**Application no: 23/00796/DISC**

**Location:** Formerley Buzz Bingo, Bolton Road, Banbury, OX16 5UL

## **Transport Development Control**

Discharge of Conditions 6 ((Construction Traffic Management Plan) and 10 (Construction Environment Management Plan) of 21/04202/F (APP/C3105/W/22/3296229

Drawing title  
Site Setup

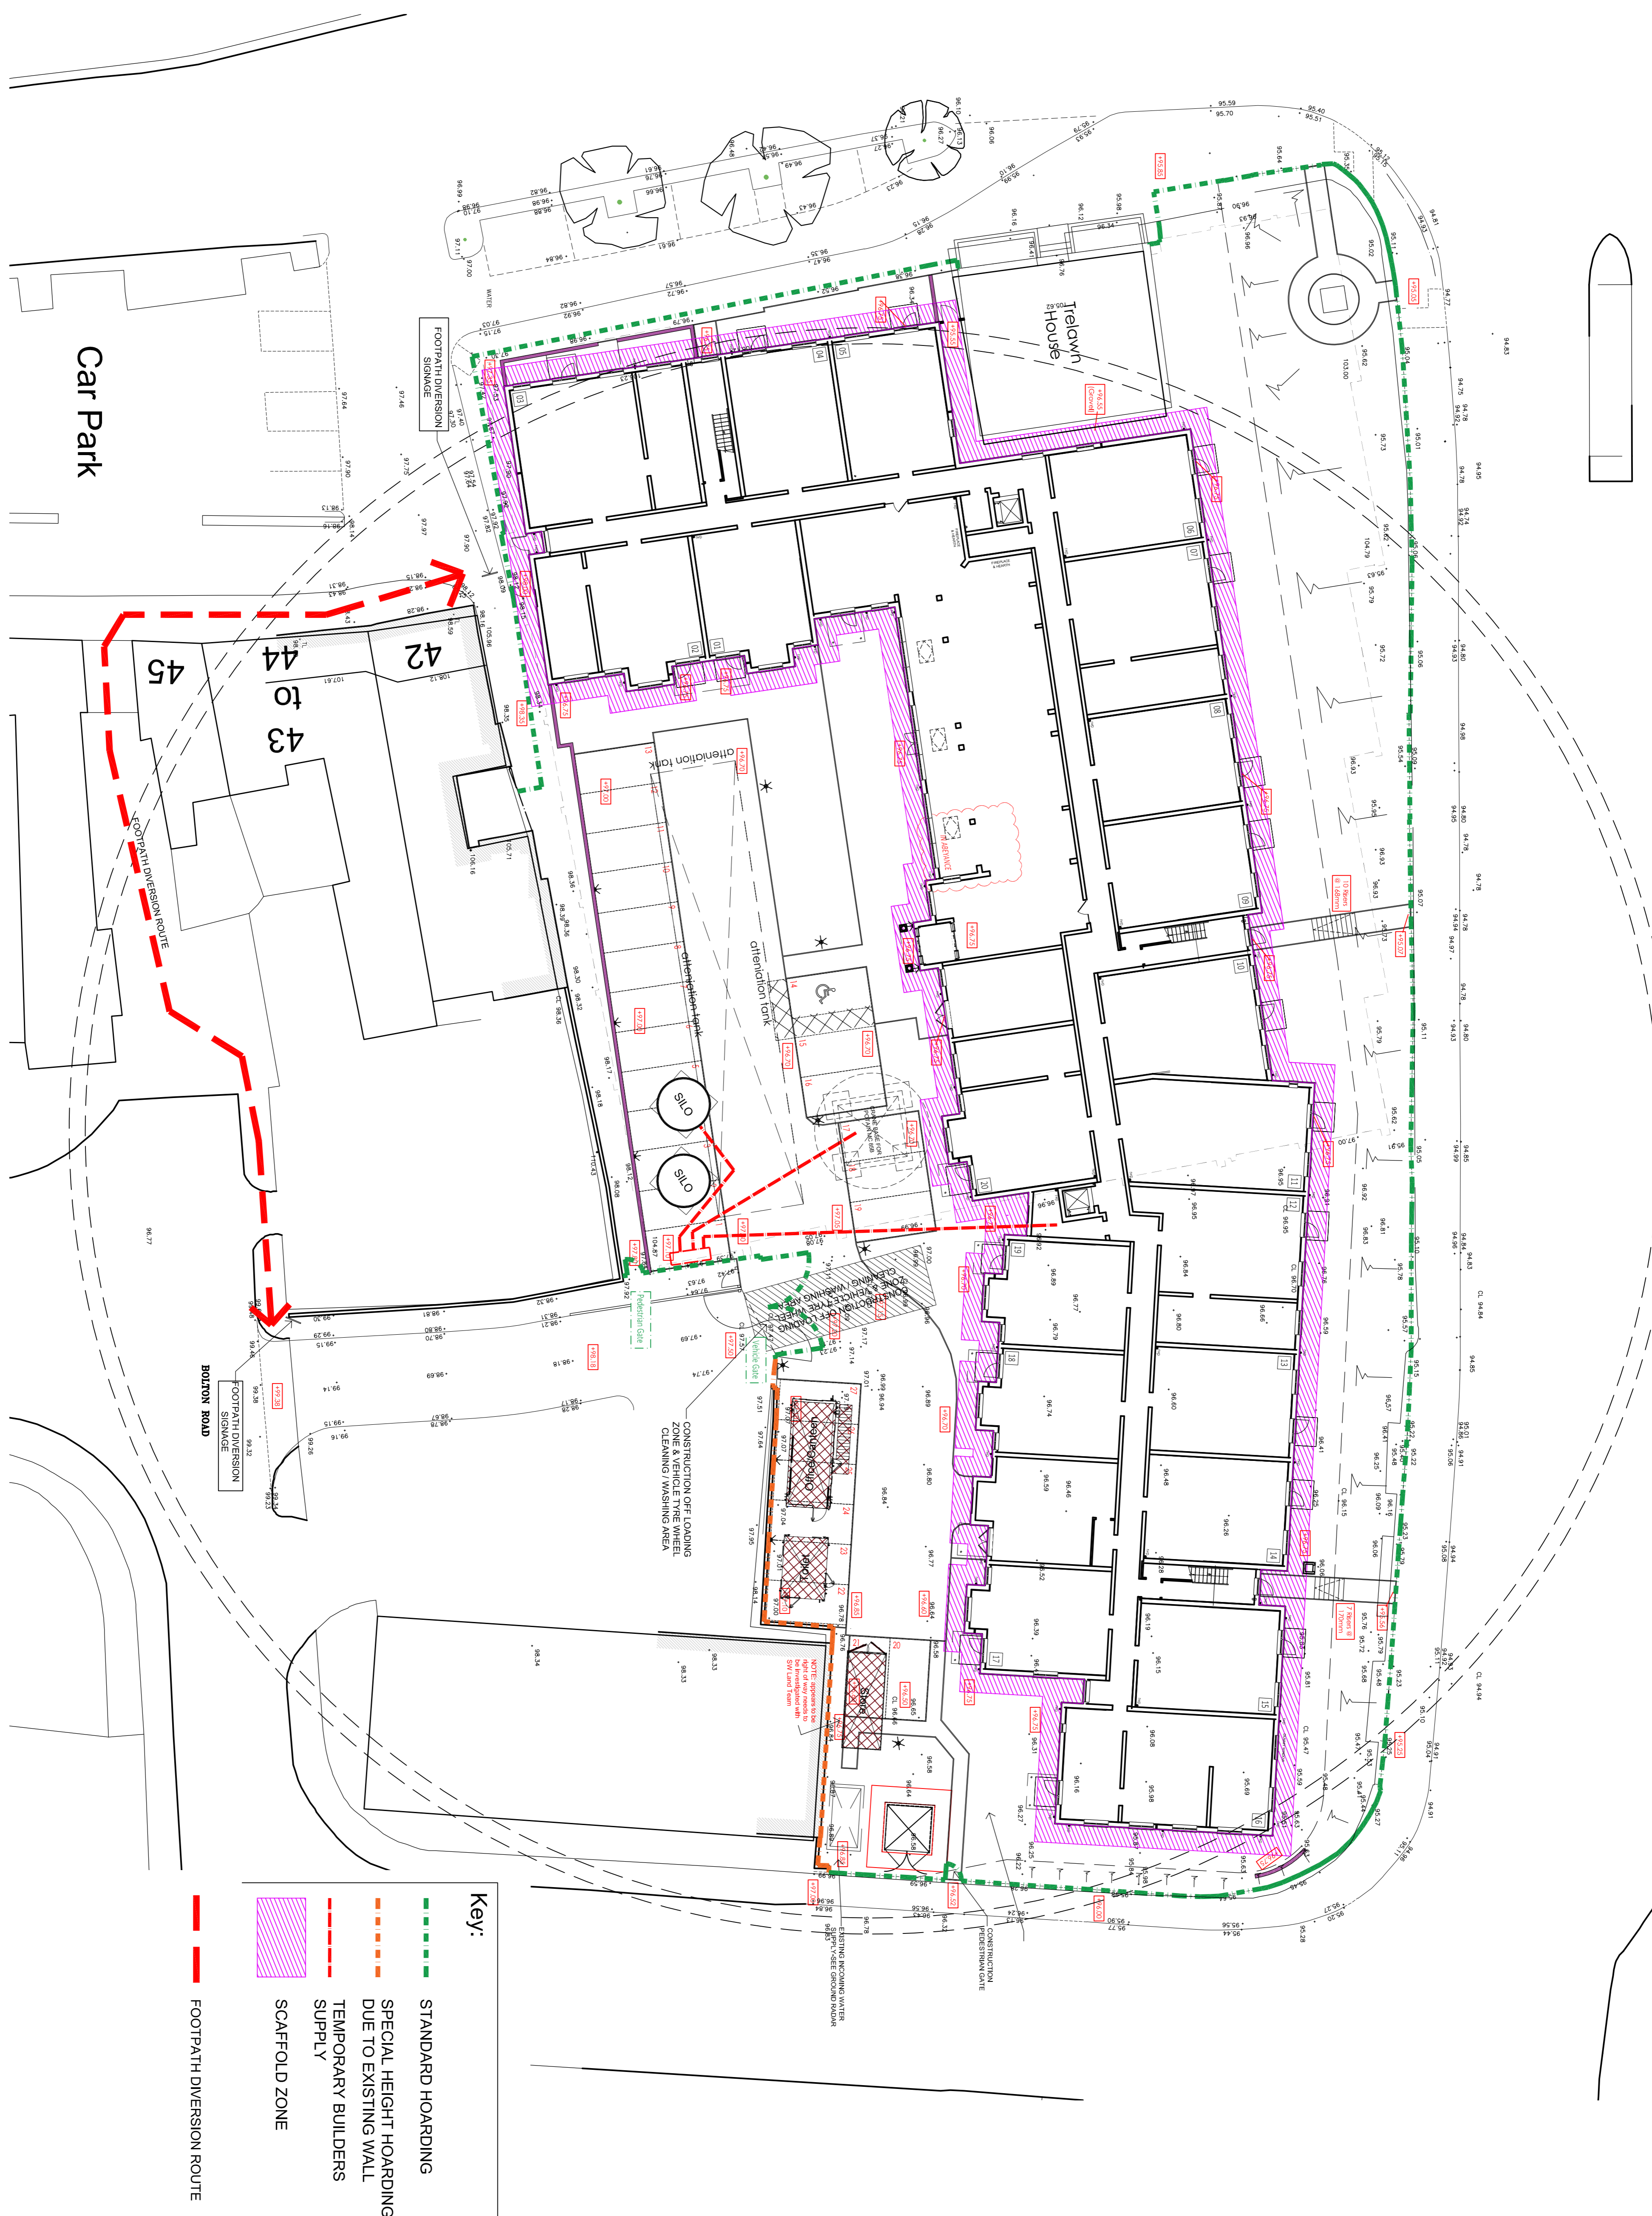
That said, Applicant has failed to submit a site Layout plan showing- structures, roads, site storage, compound, segregated pedestrian routes, loading areas, vehicle tyre, wheel cleaning / washing area, the proposed erection and maintenance of security hoarding / scaffolding details and signs etc in support of the works. We are therefore unable to discharge the conditions at this stage.

It also stated that a temporary access would be constructed, however no details of temporary access plan have been provided. The Applicant should be aware that any temporary access arrangements must be agreed with and approved by the LHA.

Also details of appropriate signing, to accord with the necessary standards/requirements, for pedestrians during construction works, including any footpath diversions must be provided.
